Rezoning Transportation Analysis

Petition Number: 2021-096

Date	Description
8-20-2021	First Review (DBS)
9-17-2021	Second Review (WB)
10-19-2021	Third Review (PDM)

The petition is located adjacent to East 36th Street, a City-maintained minor thoroughfare, with other frontages on North Alexander Street and North McDowell Street, both City-maintained local streets. The petition is located in the East Wedge inside Route 4. Applicable area plans include the 36th Street Station Area Plan.

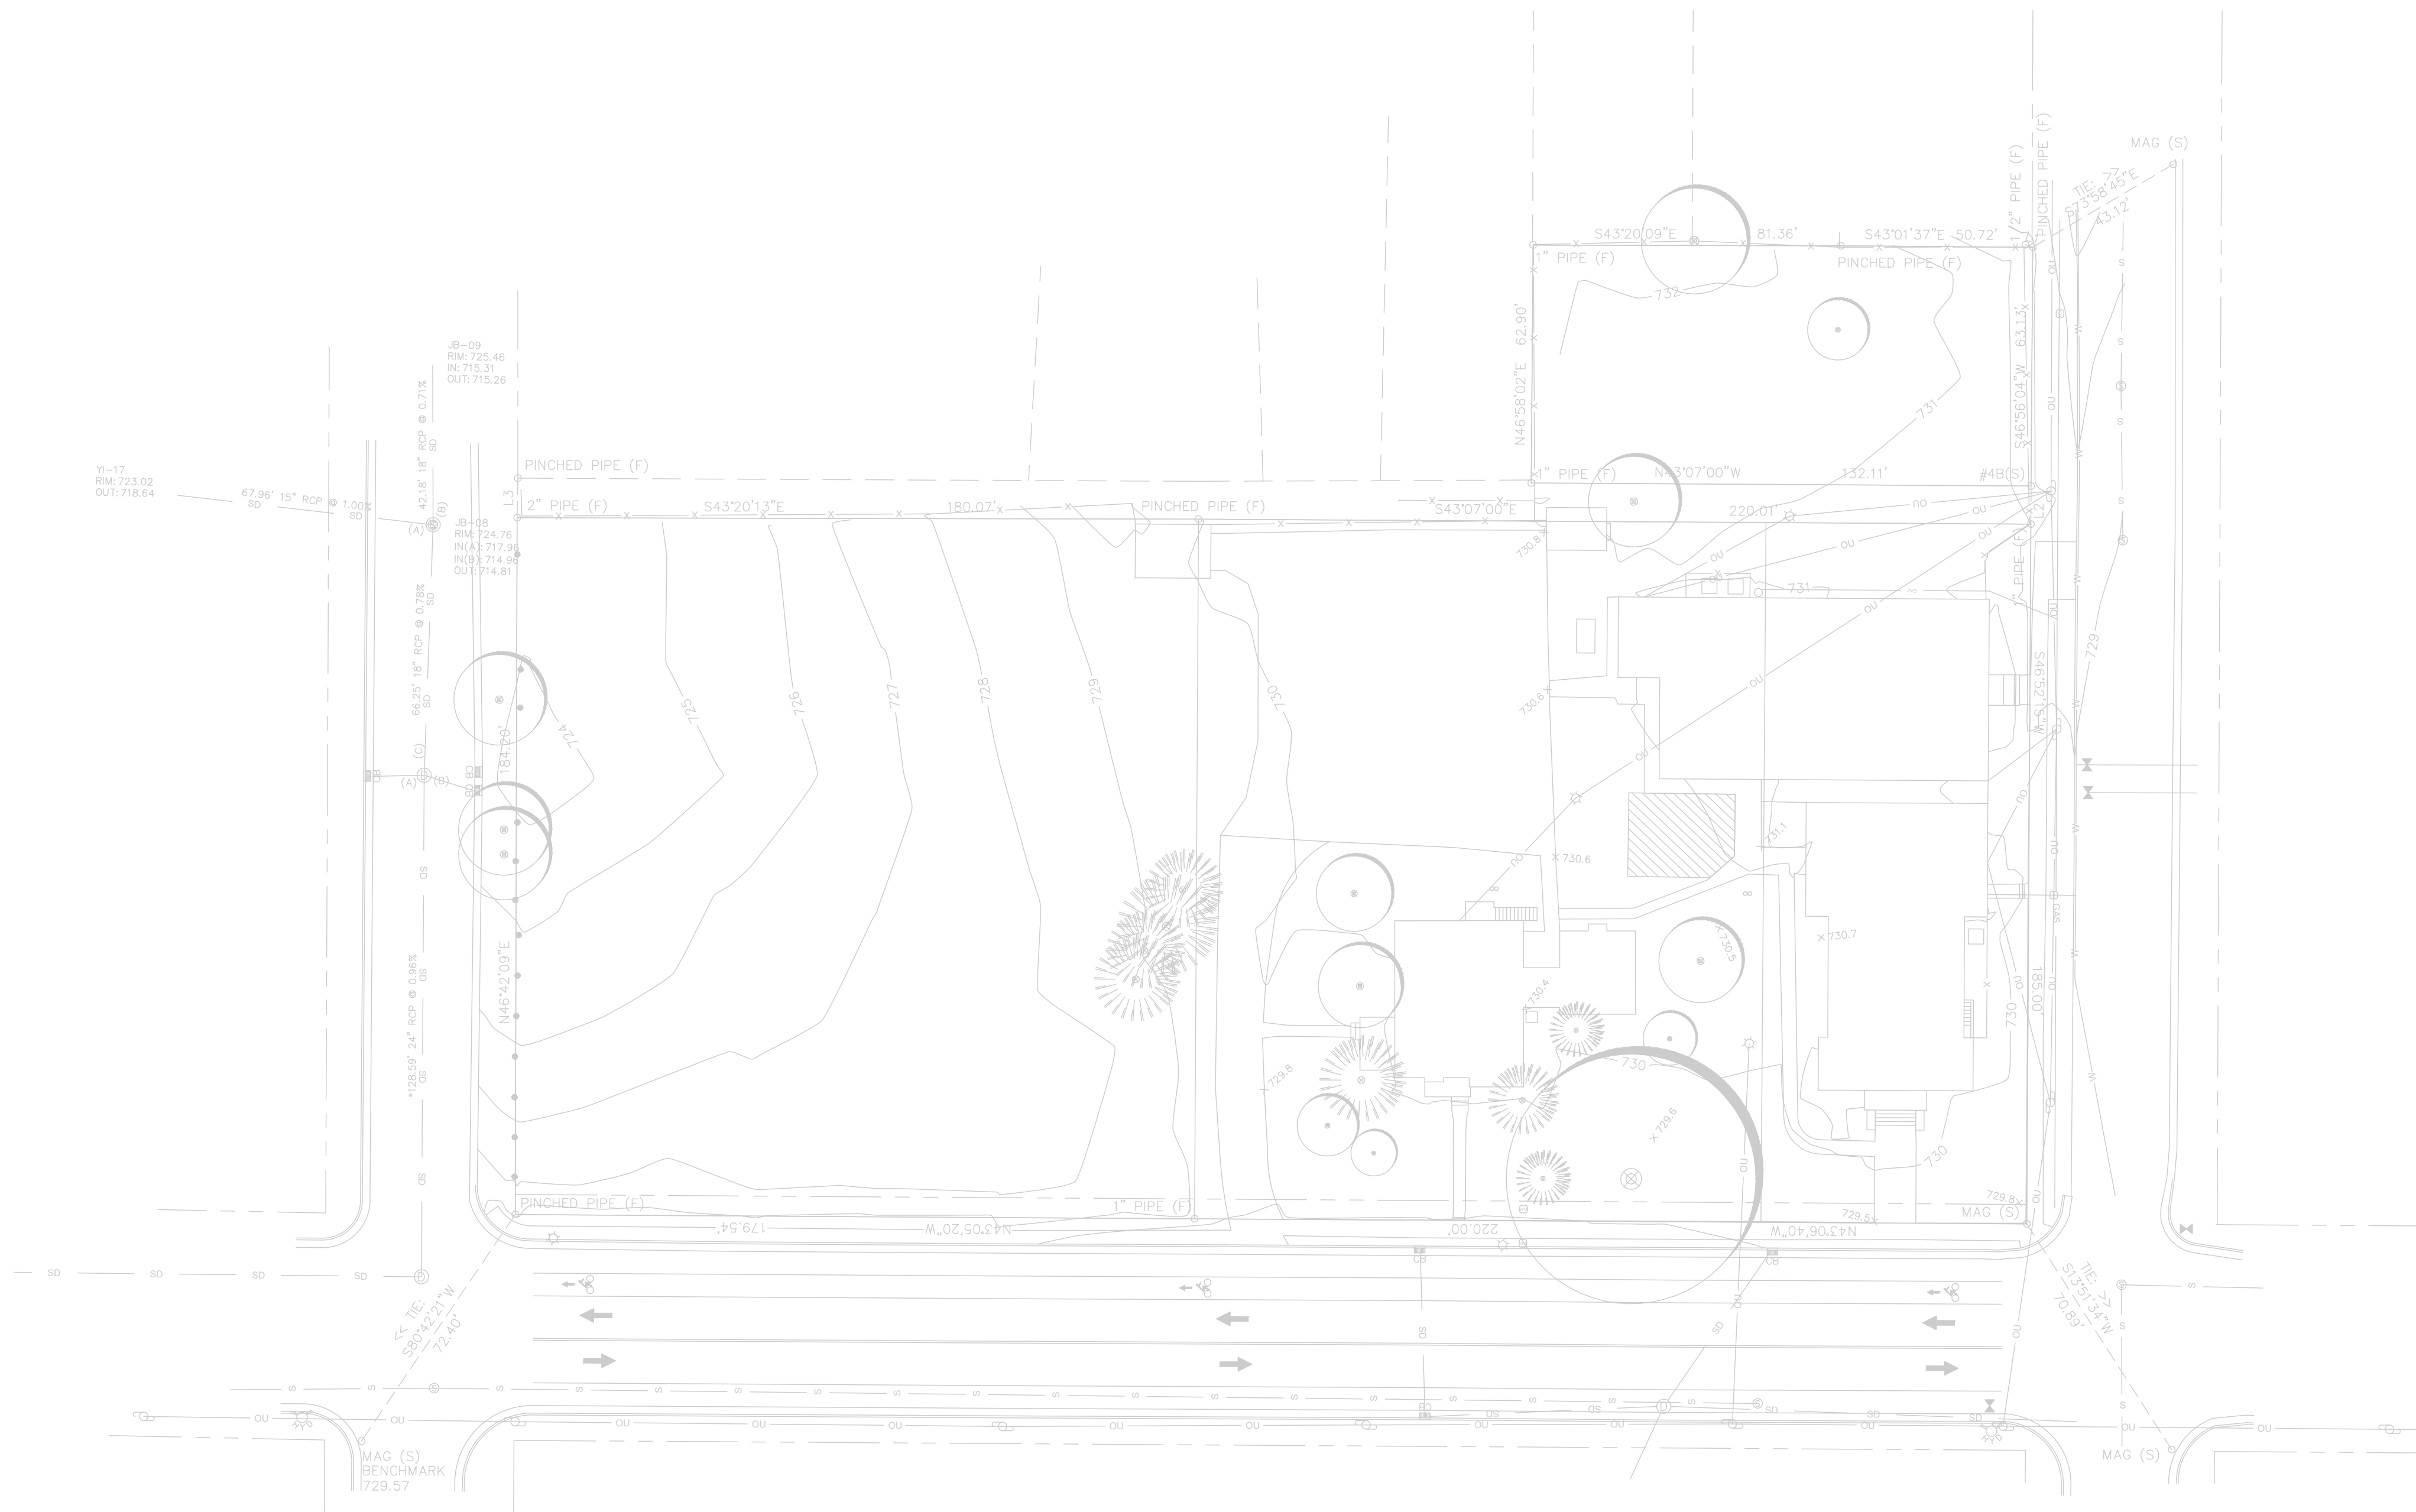
- Revise site plan to construct bulb-outs on East 36th Street at the corners of at North Alexander Street and North McDowell Street. Provide recessed on-street parking on North Alexander Street and North McDowell Street as SHOWN in the graphic below. New comment in response to request from Noda Neighborhood Board.

Revise site plan and conditional notes to construct curb bulb-outs on all corners of East 36th Street and North Alexander Street. Revise conditional notes to include the installation of Rapid Rectangular Flashing Beacons for crosswalks across East 36th Street at North Alexander Street.

Revise conditional notes to commit to installing a pedestrian crossing with a Rapid Rectangular Flashing Beacon across East 36th Street at Spencer Street. Final location of crossing to be coordinate and approved by CDOT during permitting.
